02 September 2014

KEH/CRB/sep/1068

**Re: Structural Survey and Report of Two Storey Outbuildings Attached to the Rear
North Elevation of the Main Property 12 River Road, Littlehampton, BN17 5BN.**

GROUND FLOOR PLAN 1:50 @ A3

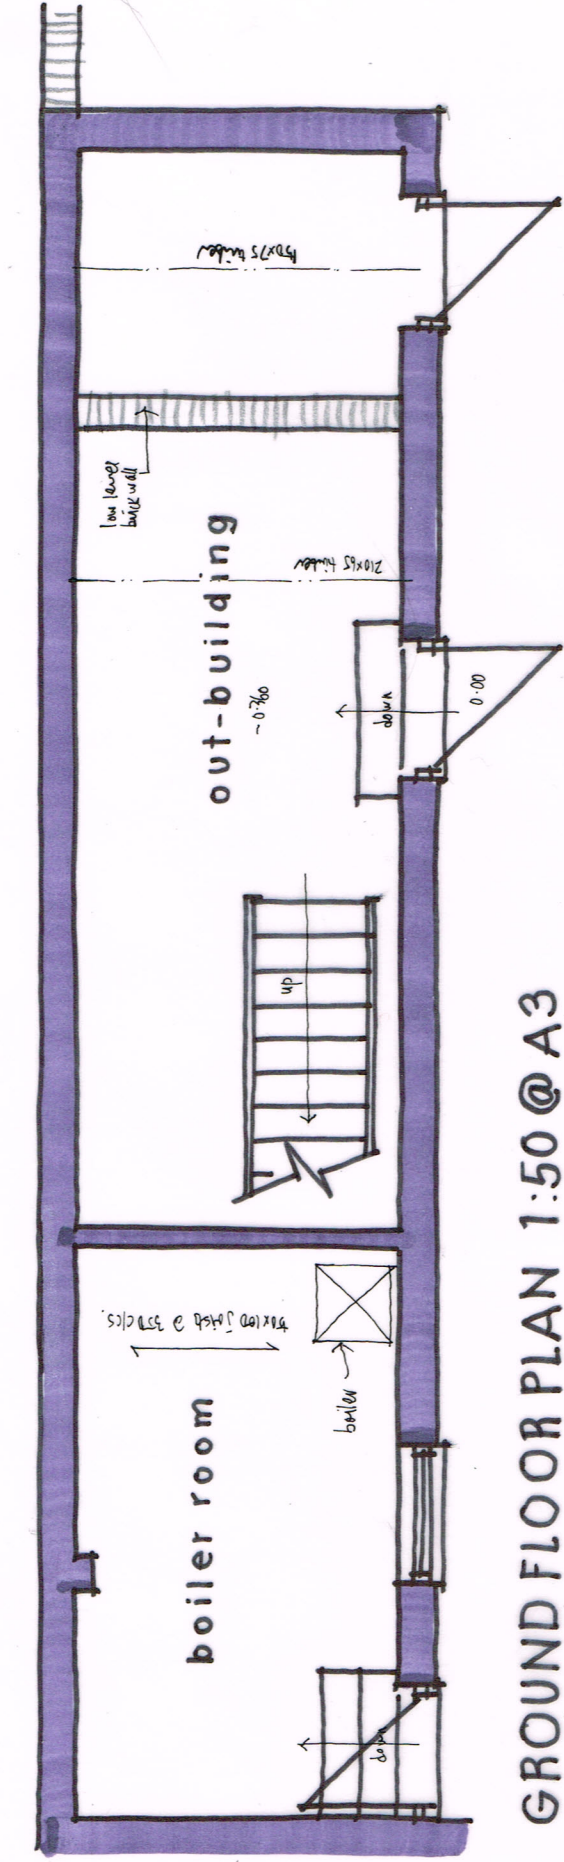
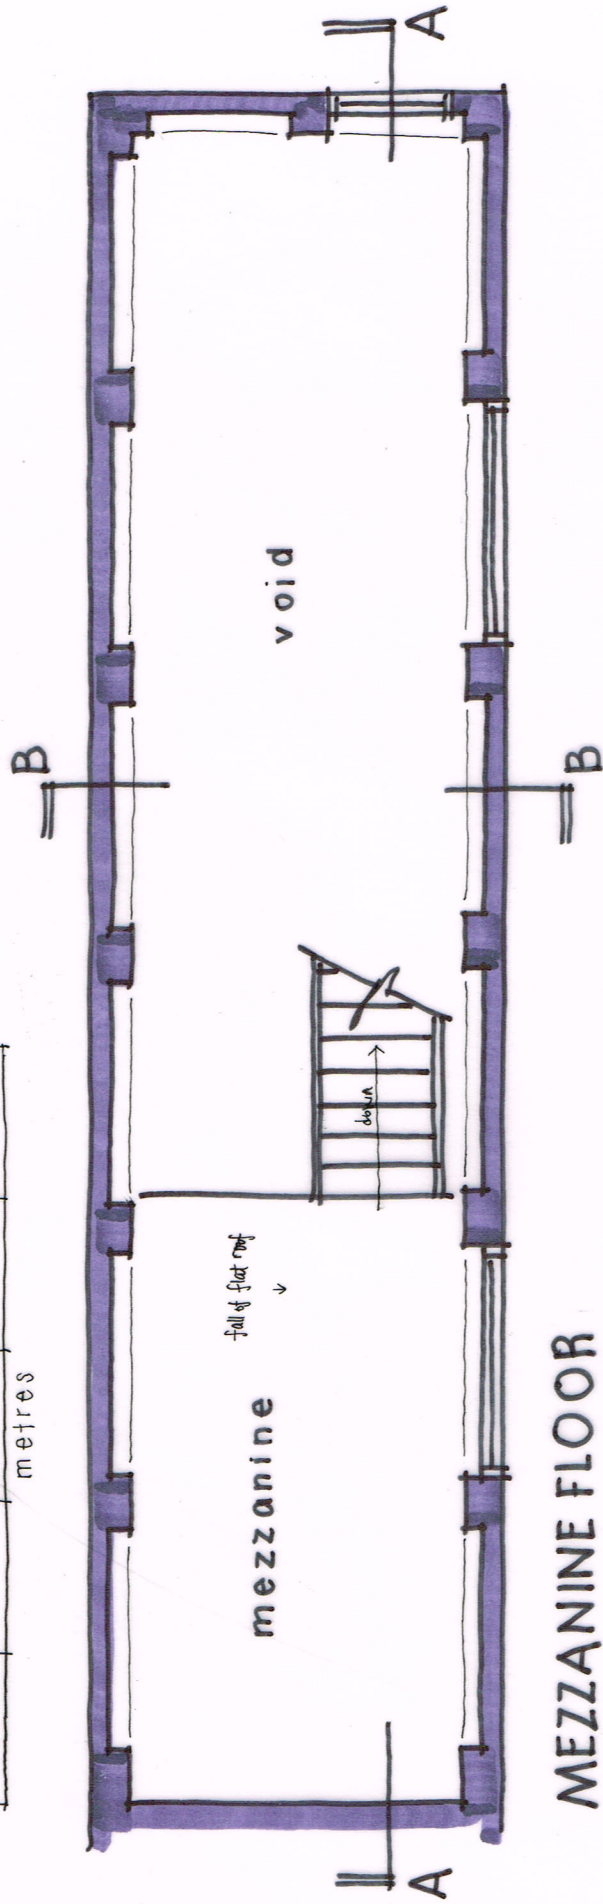
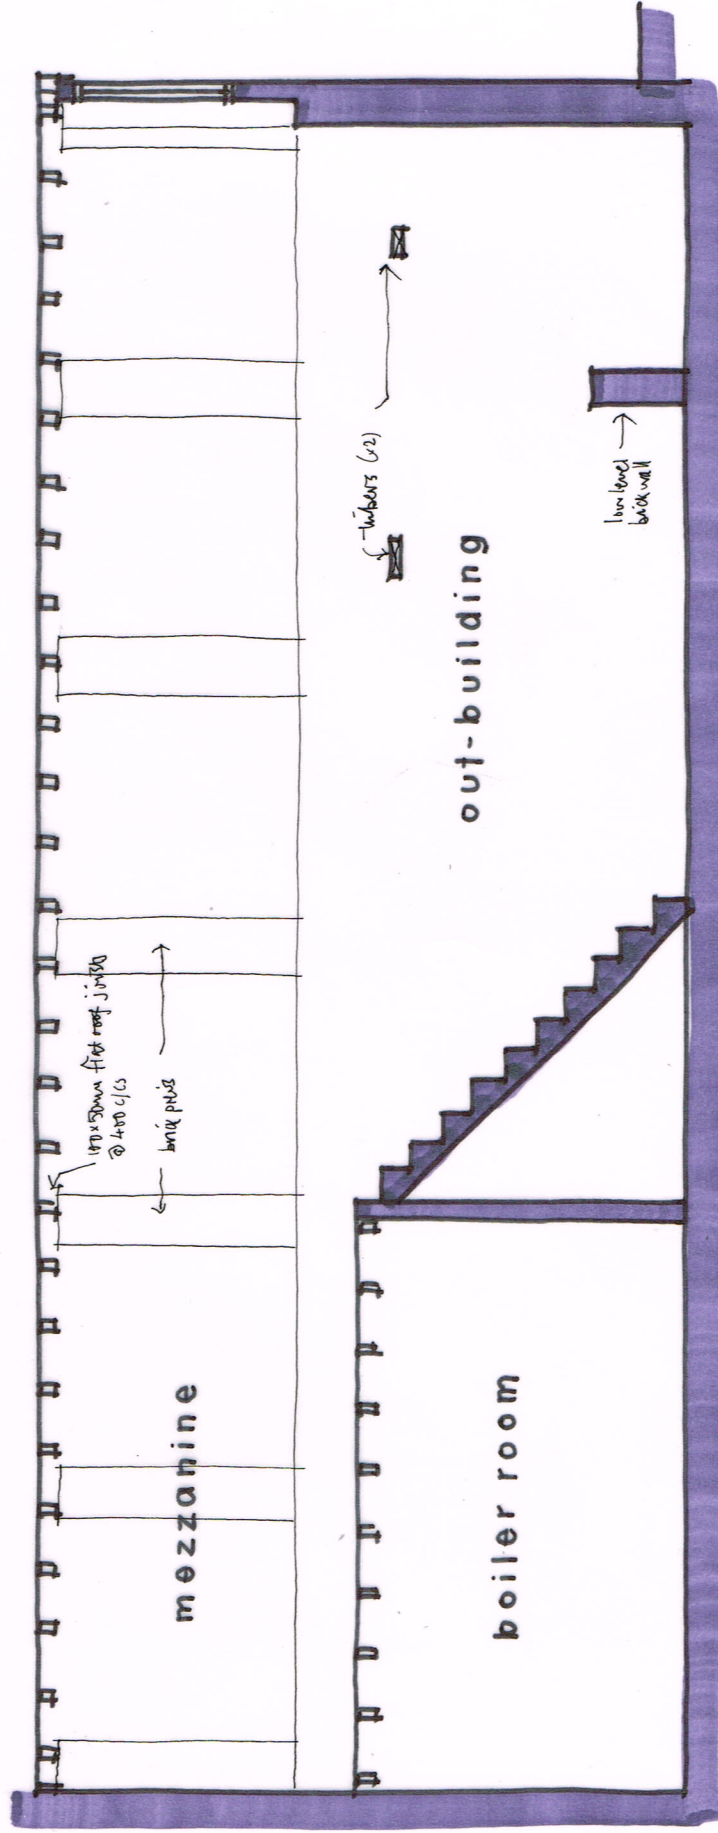
The low level flint walling to the north end is to be removed in its entirety and the floor area made good as required.

The first floor area to the north end of the storage building had been removed and only a couple of existing timber beams remained in position. These are to be removed.

6. New floor joists to be secured with joist hangers onto timber wall plate secured to existing flint walling with continuous plate suitably bolted with resin anchors into existing walling.

7. Doubled up joists should be provided to trim staircase well.
8. Existing wall plate in north elevation to be carefully cut out and replaced with face brickwork to match existing.

11. The remaining ground floor area should be treated with a damp proof membrane either three coats 'Synthaproof' or 1200 gauge polythene sheet with edges turned up the perimeter wall to at least ground floor level and turned in to existing masonry. New flooring then laid to architect's specification to give required thermal value.
12. Some isolated small areas of external flint and brickwork may require repair and repointing.

SECTION A-A 1:50

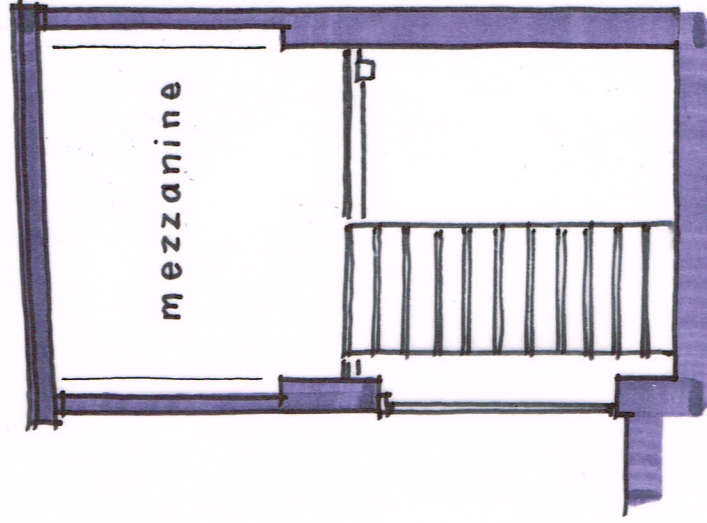
1. The flat roof joists to be checked for adequacy.
2. Where new roof lights are introduced the joists each side and trimming joists should be doubled up.

3. The existing timber wall plate should be adequately strapped down to the inside face of the existing brick walling with 20 x 5 galvanised mild steel straps at maximum 2M centres for a length of 1.5M.

4. The new stud walling construction above first floor built between existing piers should be supported on new sole plate bedded in sand and cement together with new header plate. Stainless steel angle ties should be fixed in mid height and screwed back to inside face of face brickwork. This detail to ensure adequate stability of walling above first floor.

END (n)

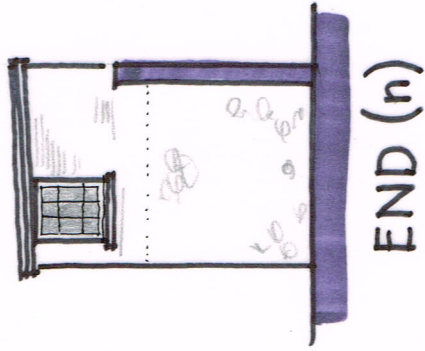
In the north elevation at the junction of the flint walling with the face brickwork was a timber plate in poor condition and this should be removed and replaced.
